Reference: 2021/62/94552/E

Proposal: Erection of 53 dwellings and associated works | Land at, Barnsley Road, Denby Dale, Huddersfield, HD8 8TS

Objection – impacts on unmapped ancient woodland and access

Effects on Tanner Wood and Wildlife Habitats

PROPOSED SITE ACCESS

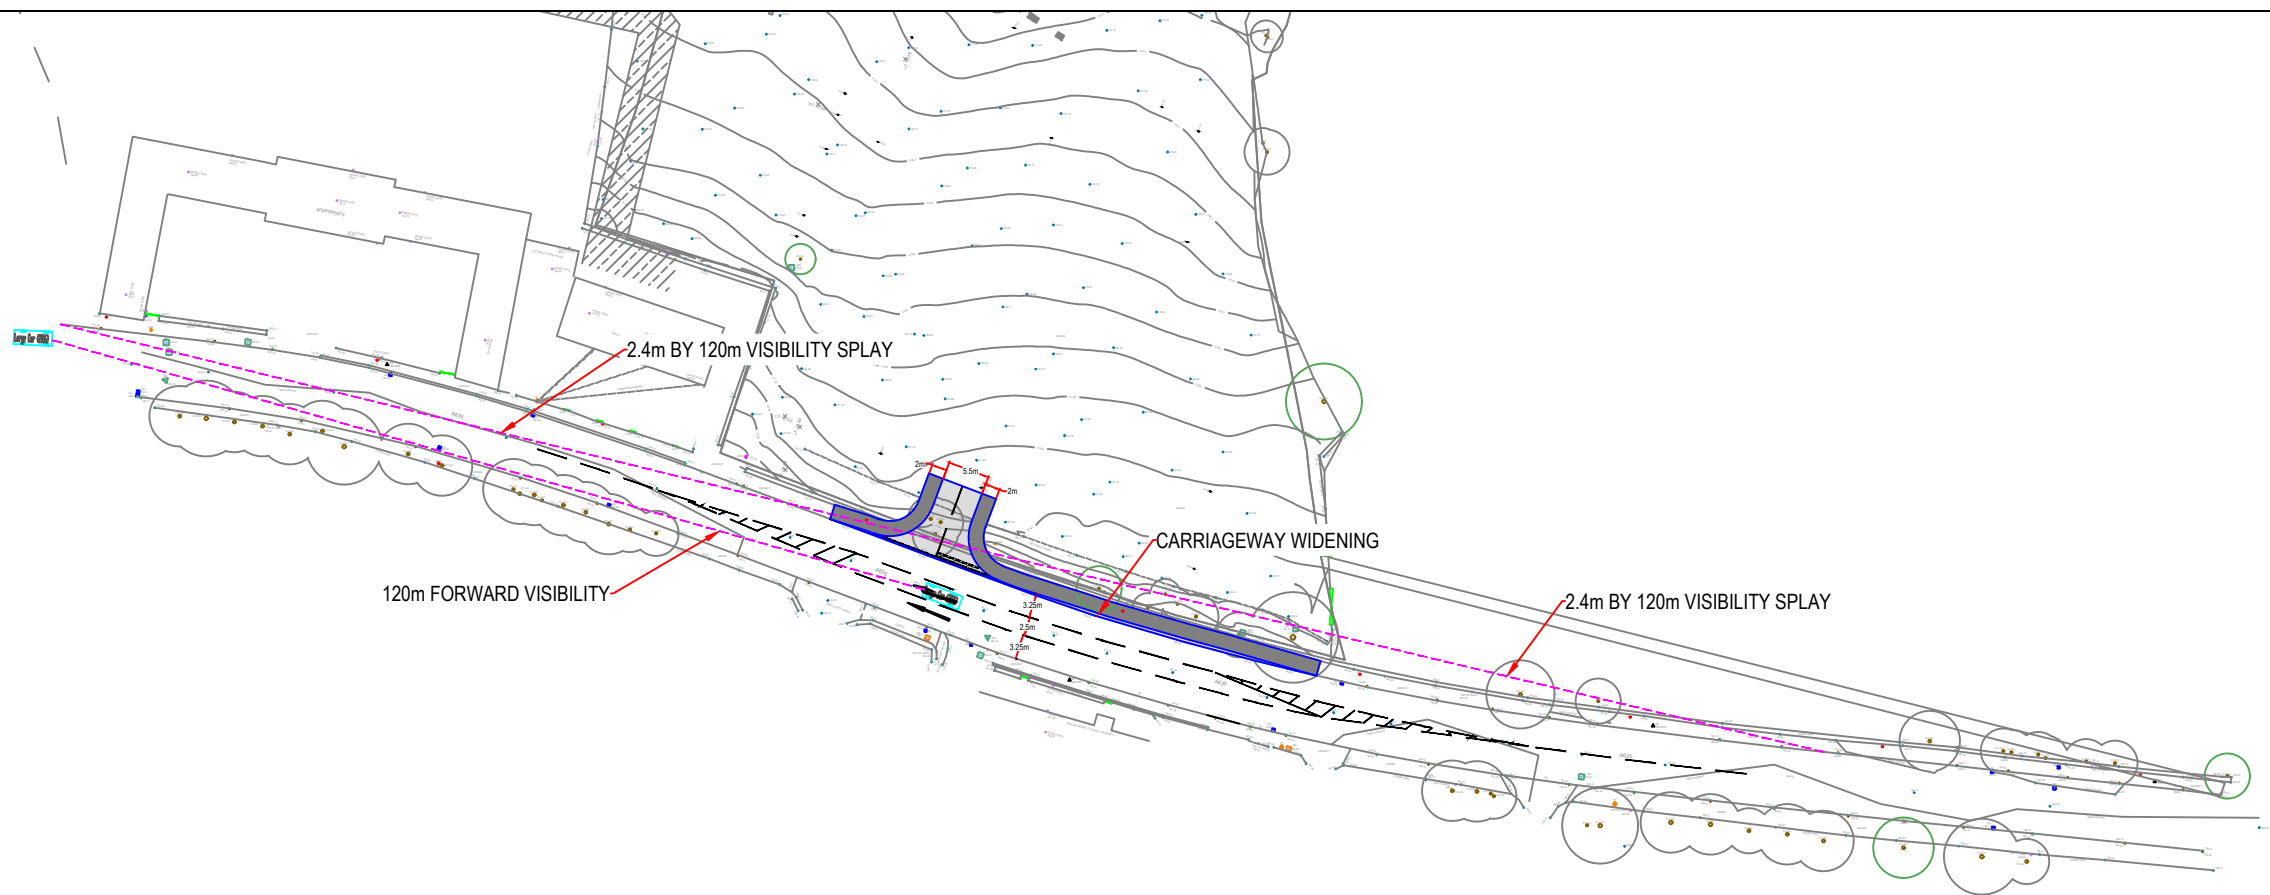
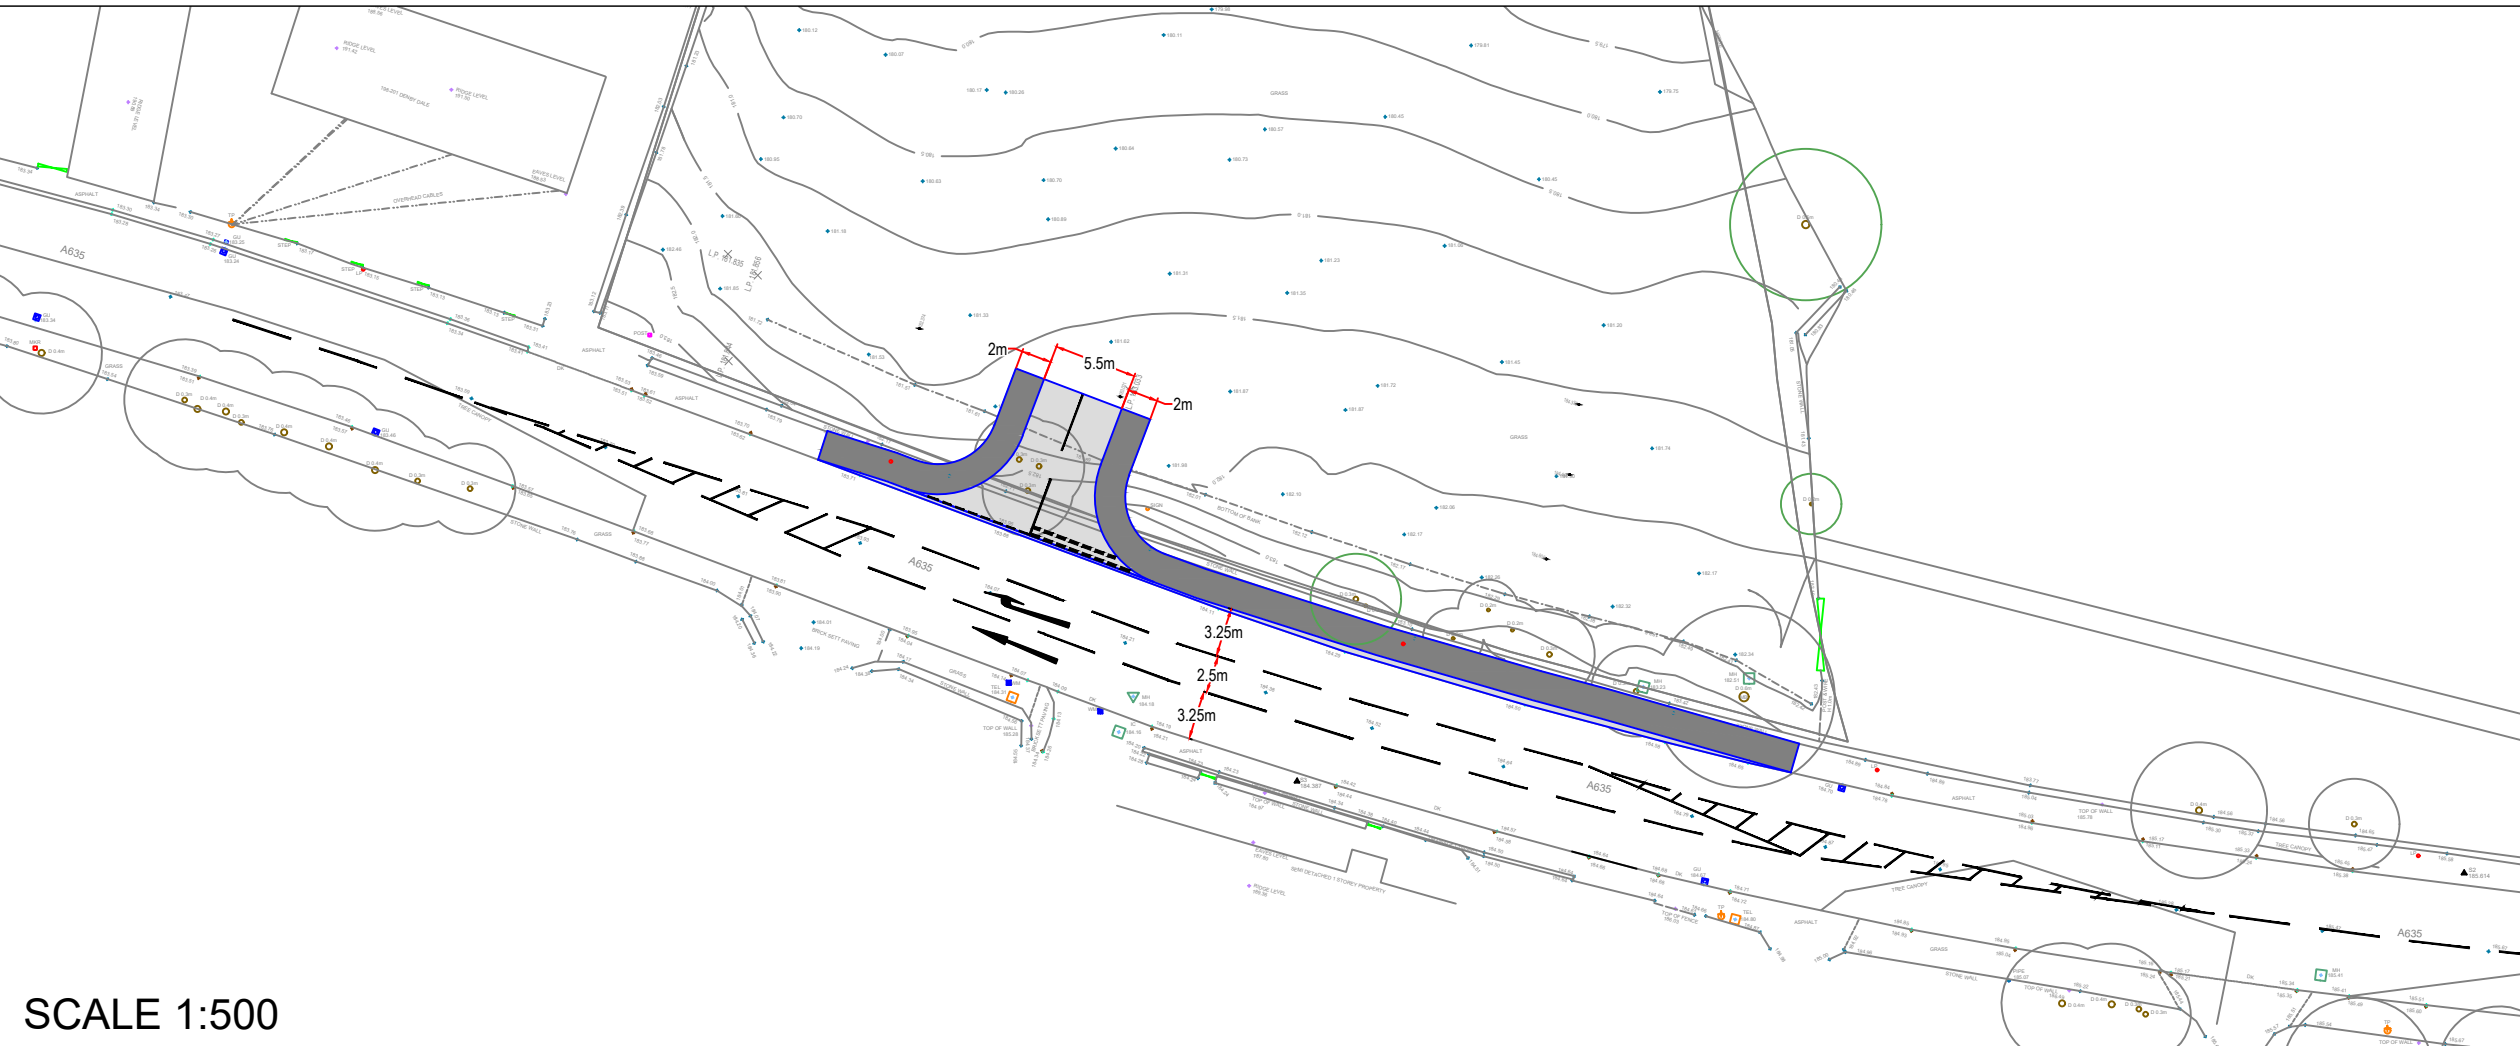
I live opposite the proposed entrance to the development, which I believe could be in a dangerous position. Myself, my neighbour and others park on the road side. I don't think such matters have been taken into consideration on the plans.
